Ribble Valley Borough Council  
Housing & Development Control

Application no: **3/2023/0246**

Address: **Land adjacent to Southport House Hollins Syke Sawley BB7 4LE**

Proposal: **Proposed demolition of four existing agricultural buildings and construction of two self-build family eco-homes.**

Figure 7: Existing and proposed site plans

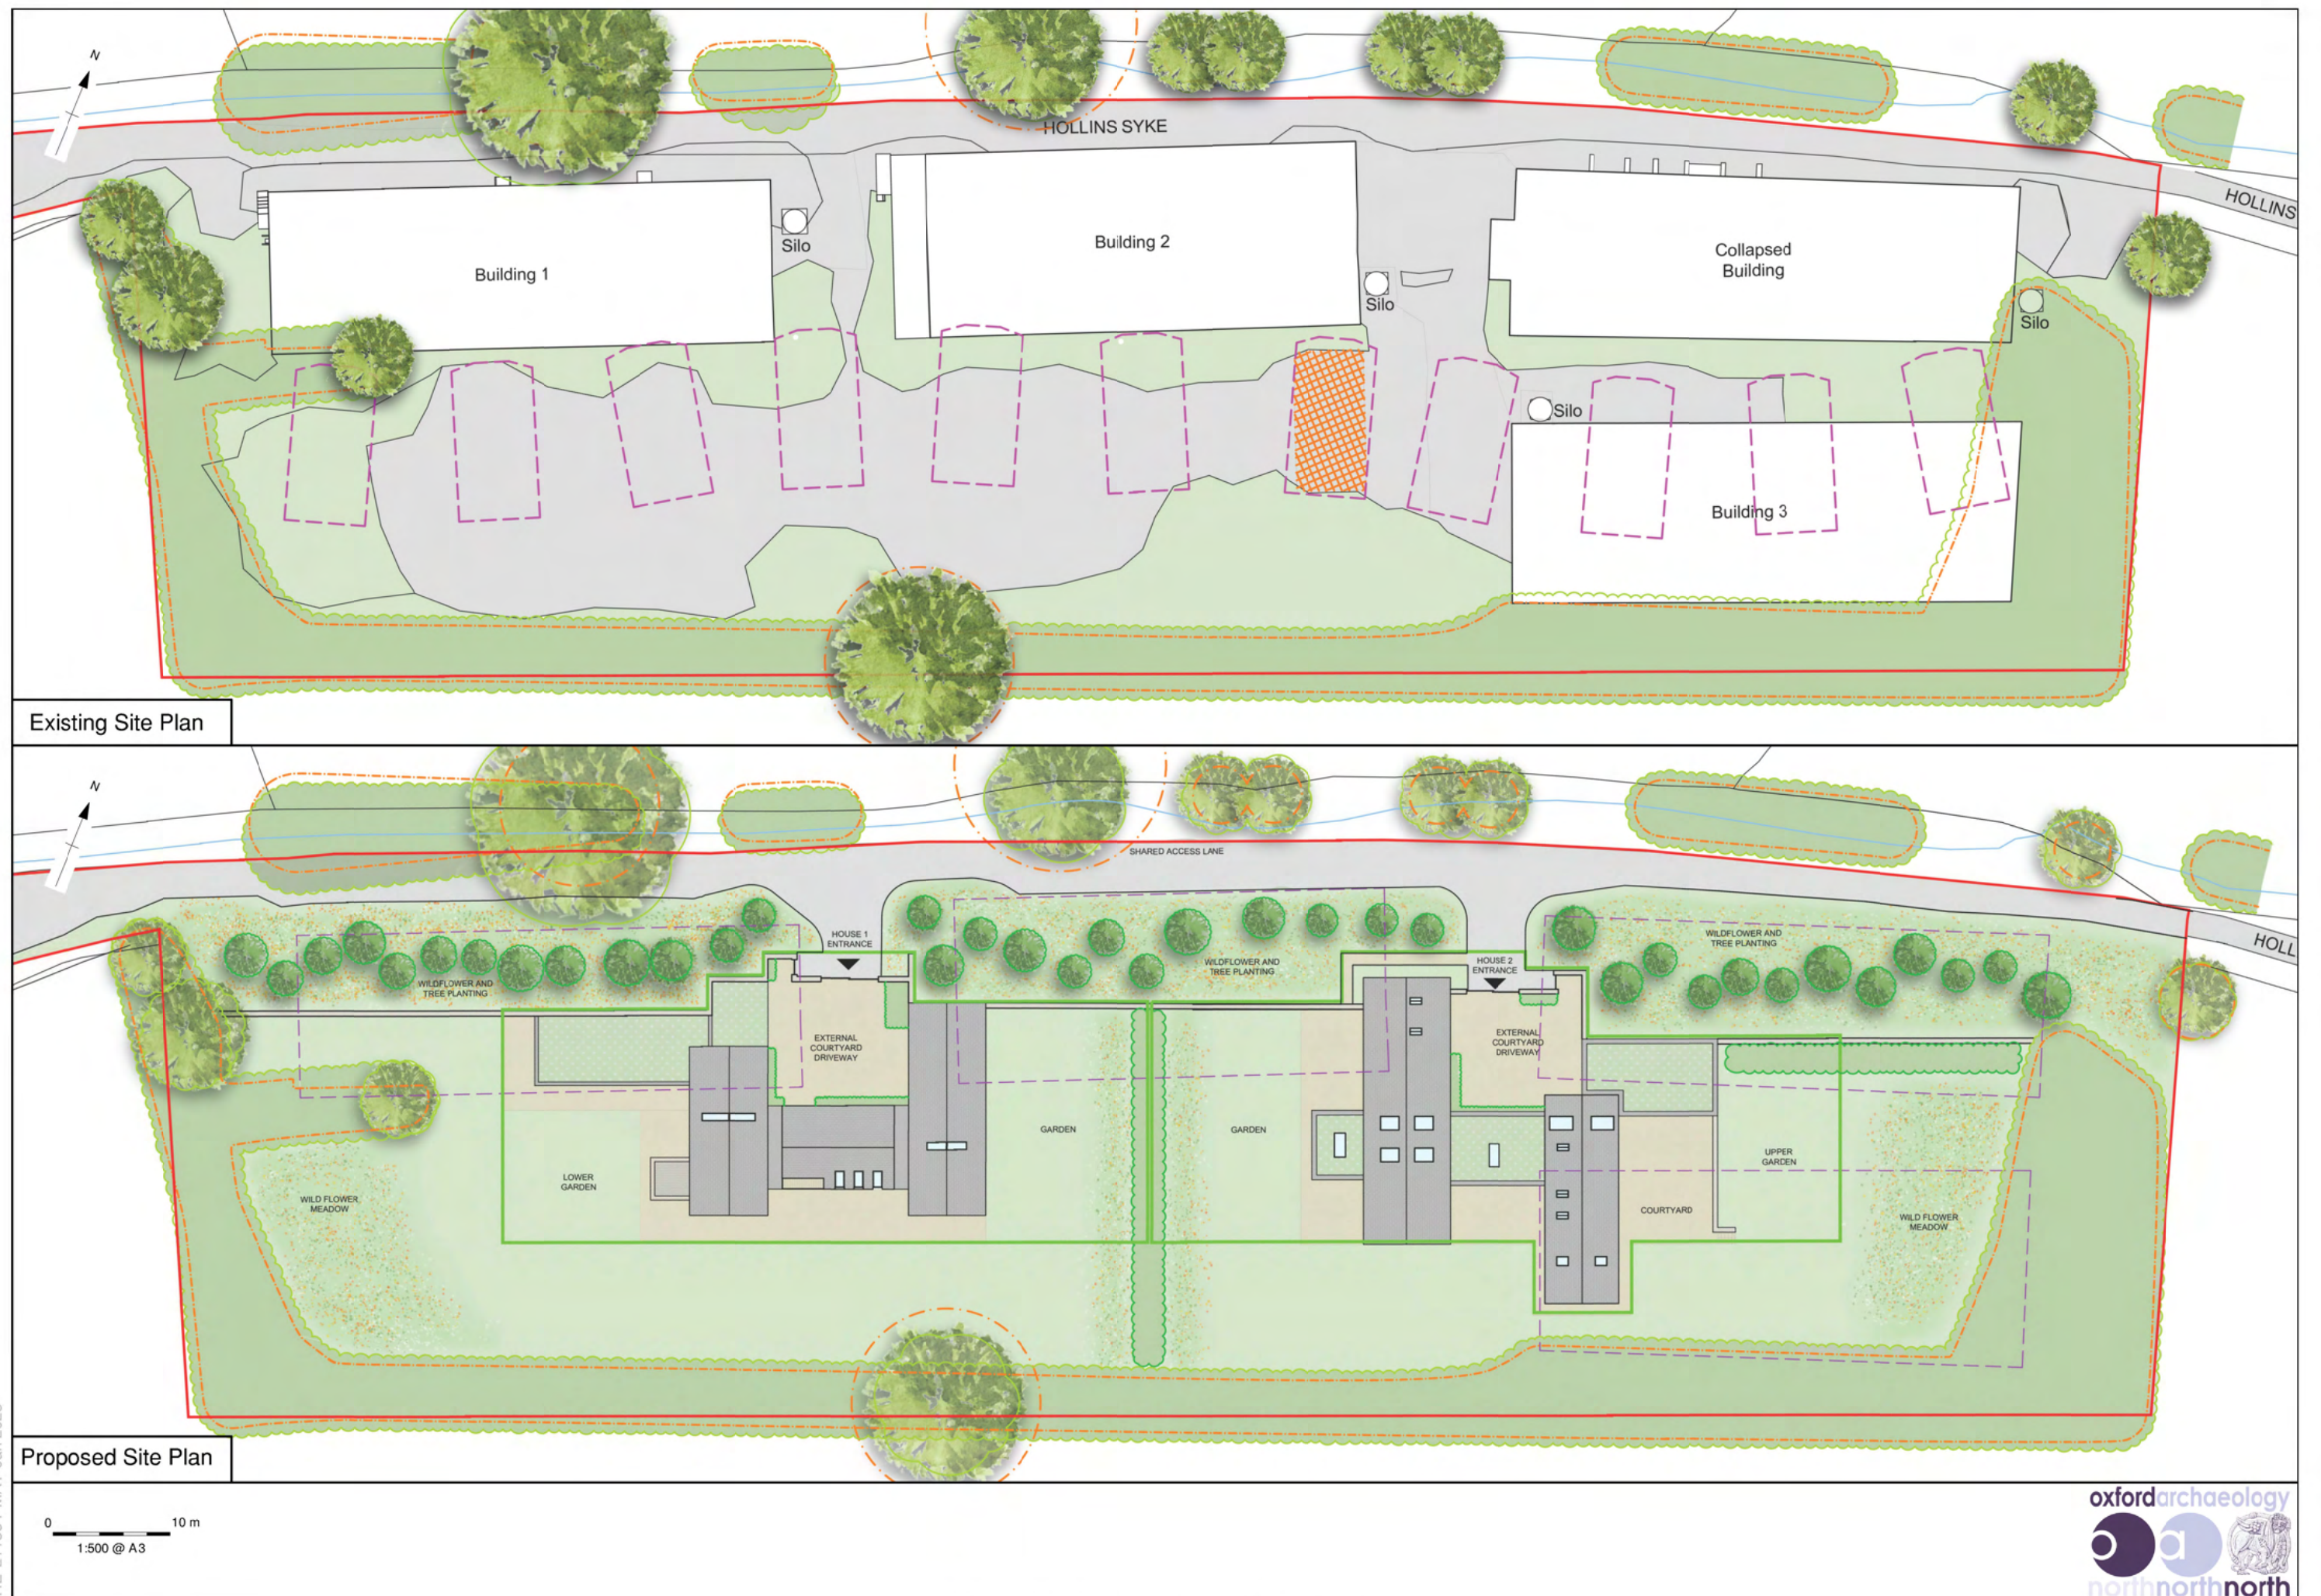
The LHA have reviewed ZMA drawing number P01.02 titled "Proposed Site Plan-Ground Floor Plan" and are aware that a minimum of 3 car parking spaces can be provided for each dwelling. This complies with the LHAs parking standards as defined in the Joint Lancashire Structure Plan given the number of bedrooms each dwelling will occupy.

The LHA have also reviewed ZMA drawing number P01.02 and have no objection to the creation of separate accesses for the 2 dwellings.

2. The development hereby permitted shall not be occupied until such time as the parking and turning facilities have been implemented in accordance with ZMA drawing number P01.02. Thereafter the onsite parking provision shall be so maintained in perpetuity.
